Comments for Planning Application 21/00322/FUL

Application Number: 21/00322/FUL

Address: 24 Rosamund Road Oxford OX2 8NU

WEST ELEVATION

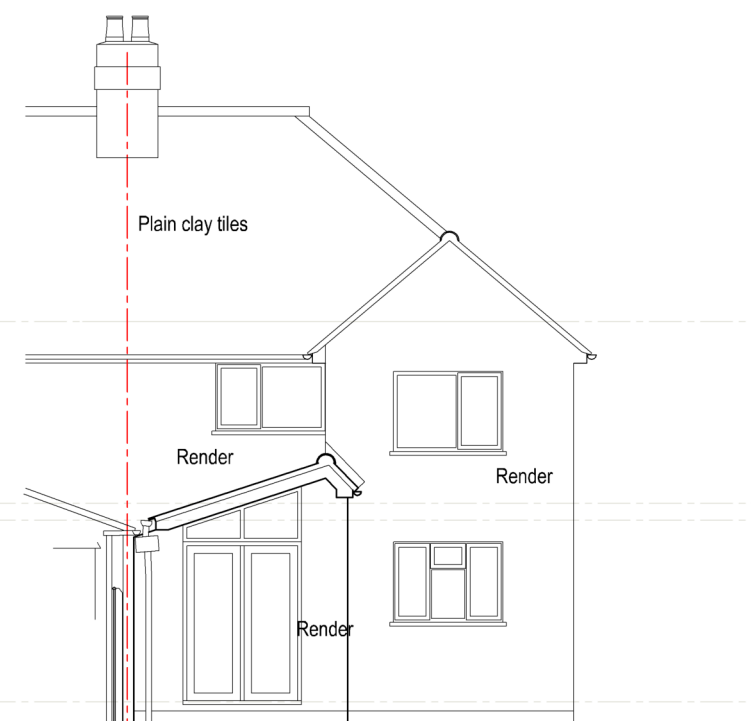
I would however like to support other comments made that mention the loss of the diamond and insertion of a window on the West Elevation at the front of the house. The diamond feature does indeed lend to the character of the houses on Rosamund Road so it would be a great shame to see it go. A window on the North Elevation at the side of the house would surely achieve the same light into the property?

EAST ELEVATION

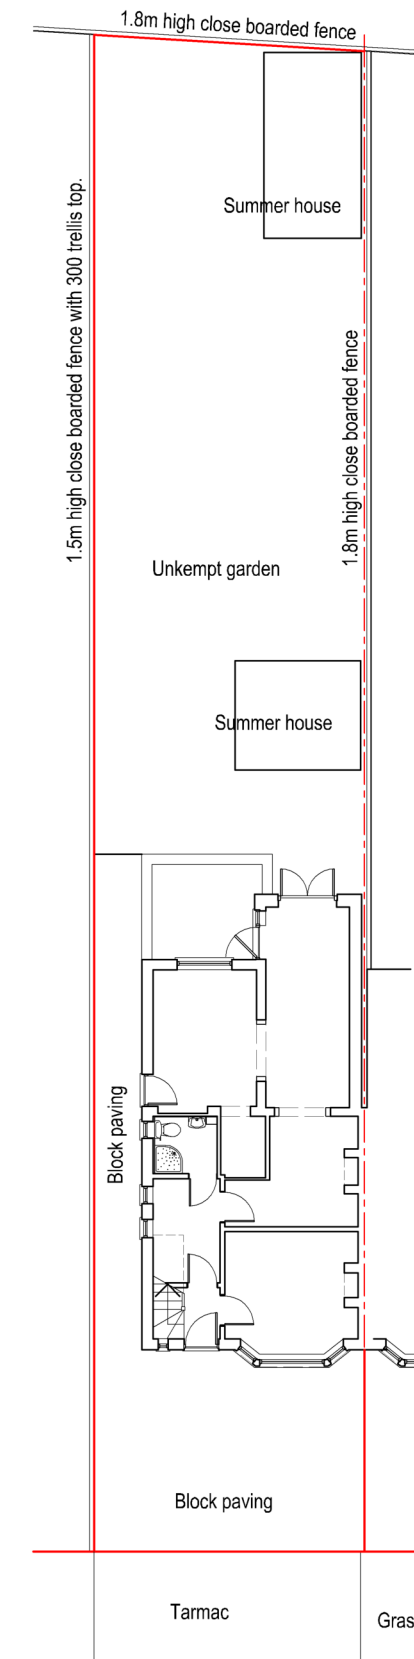
Comment: I would like some more information about the proposed "new lead box guttering" on the East elevation plan which appears to be referring to replacing the existing guttering on my extension. I am happy to work with the new owner on this and look forward to seeing the significant proposed improvements to the property in general.
